Issue Specific Hearing 2

Supplementary Agenda Additional Questions

The purpose of this document is to set out Cumbria County Council ('CCC') and Eden District Council ('EDC') singular or joint ('Councils') responses to the Examining Authority's ('ExAs') Supplementary Agenda Additional Questions issued on 22nd November 2022.

Drawing Title: Classification of Roads Plan Regulation 5(2)(o) Sheet 1 of 2

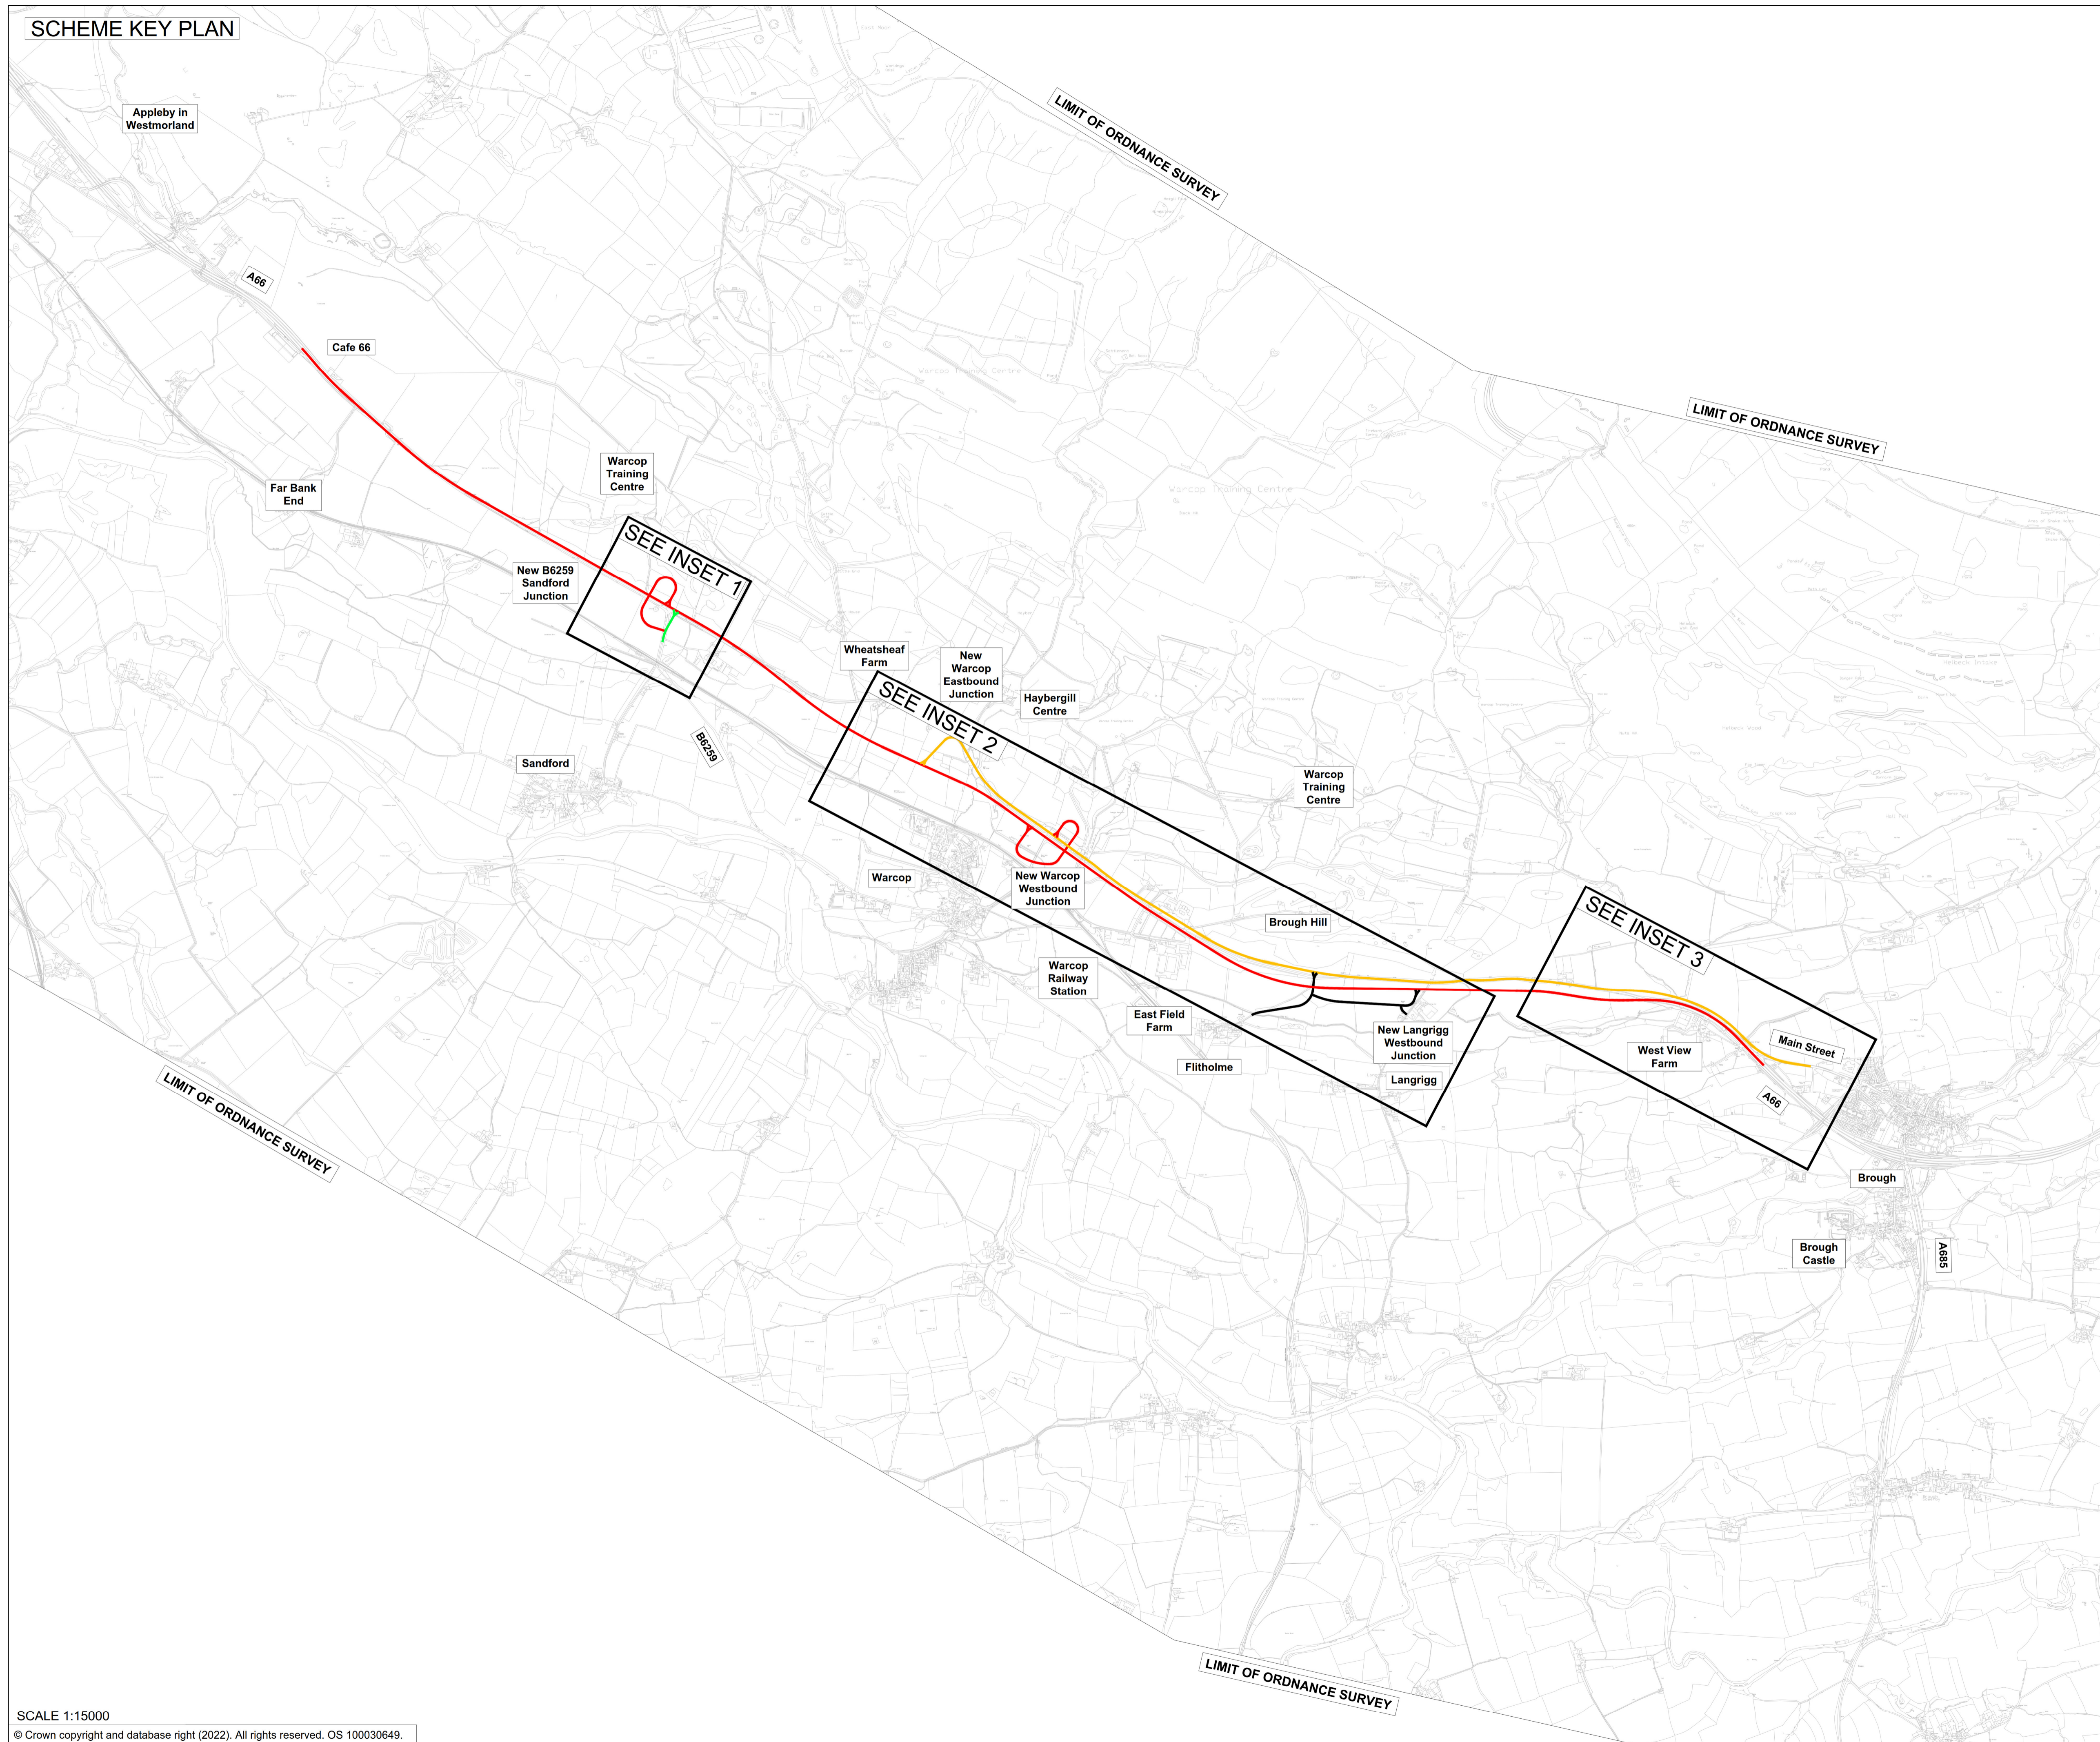
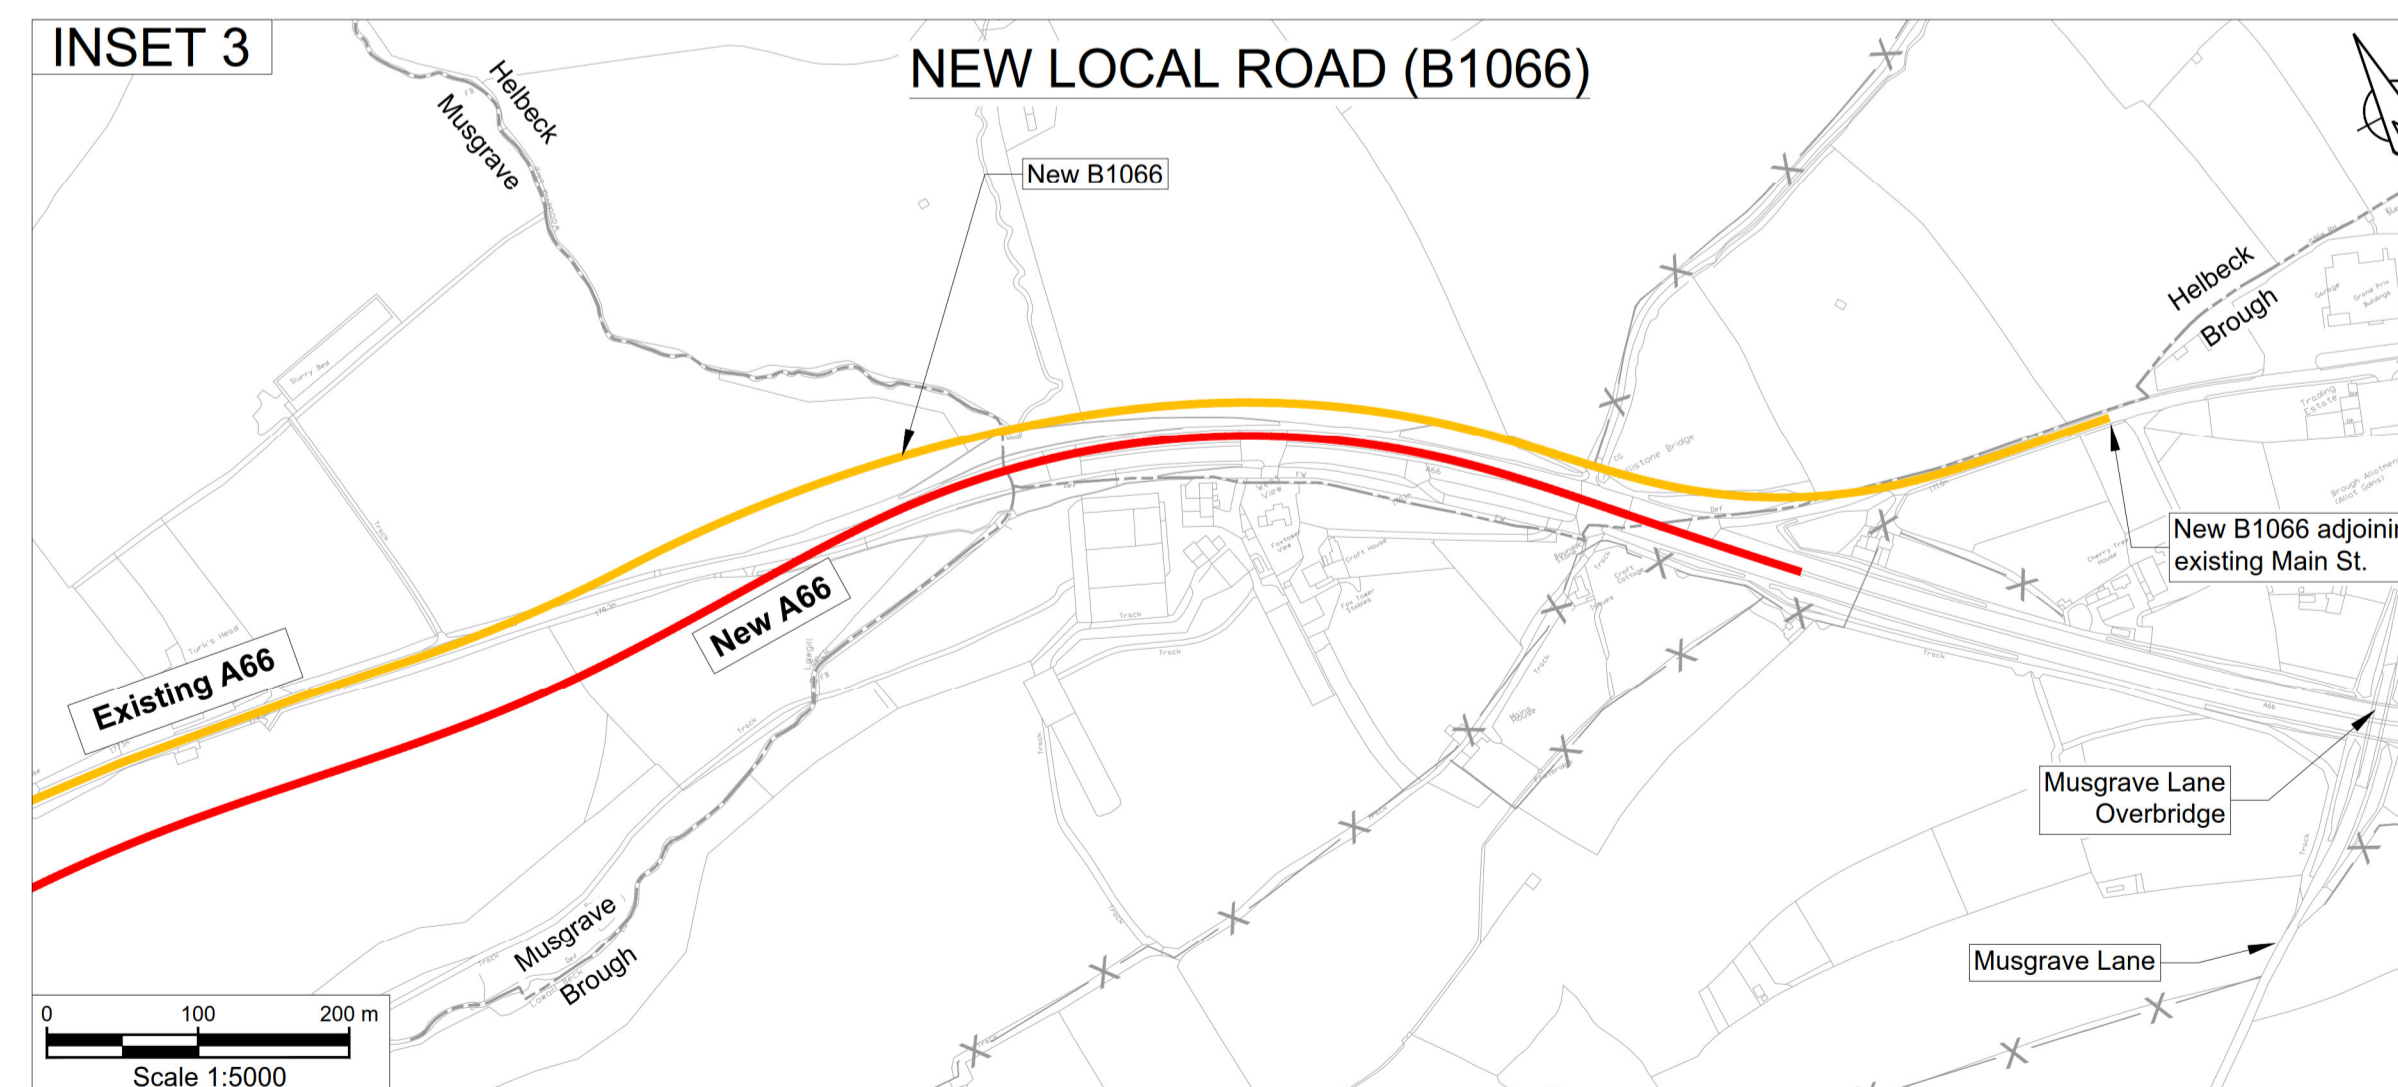
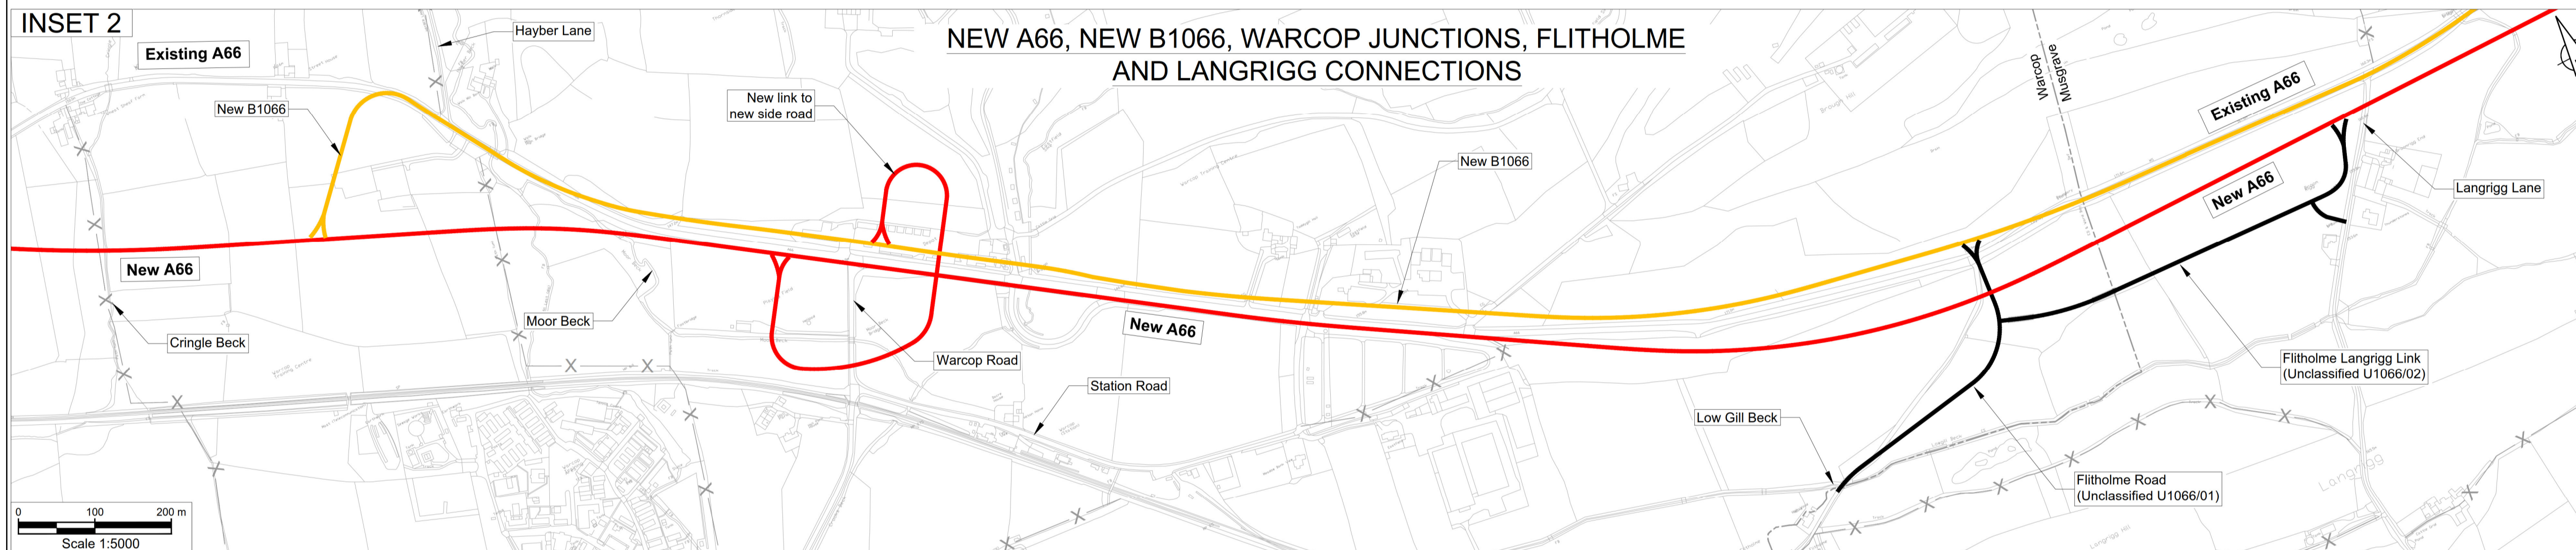
ISH2.DCO.19		Applicant and Cumbria CC	Paragraph 56 (b) sets out that the B1066 ends at “ <i>a point 254 metres west of the junction of Musgrave Lane and Main Street</i> ”. Confirm that this is that a suitable point to start a classified road on the unclassified Main Street. Confirm whether it would be more conventional to connect the new B1066 to the existing B6276 on Main Street at its junction with New Road.	CCC does not believe that the point indicated in Schedule 7 for the B1066 is a suitable point to start a classified road. CCC confirms that it would be more appropriate to connect to the existing junction on B6276.
ISH2.DCO.20	Schedule 8, Part 4, Revocations and Variations of Existing TROs	Applicant	There is an existing signed no entry restriction for westbound traffic on the extension of Main Street to prevent westbound traffic accessing the eastbound off slip of the A66. Confirm whether this would need to be revoked as this is intended to become a two-way B1066.
